### Compulsory acquisition hearing-

### Landscape and Visual

Figure 11.1: Study Area – Tourism Assessment Study Area

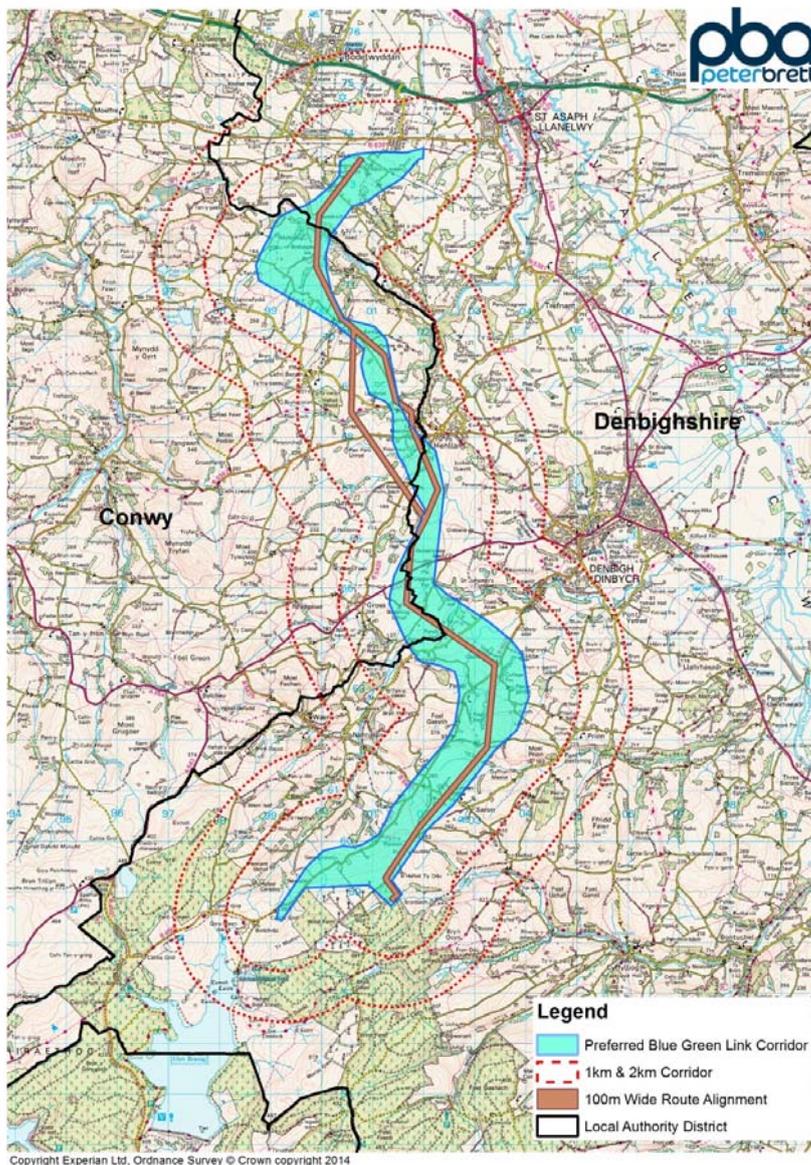
- Tourism survey had not contacted or probably identified most tourism businesses in the study area.
- It was stated that whilst the A543 was described as a principal tourist route that the survey stated that it was 1km away from the development and that there was no view of it in assign it as a minor effect. The effect on the A543 should be reclassified as well as looking at the Brening which has been ignored due to the fact that the actual centre is outside the area not taking into account that part of the lake, cycle tracks and walking paths are in the study area.
- Tourism effect has included mitigation measures as part of the survey some of which the applicant state that there are no guarantees that they will happen such as the 2 for 1 tree planting
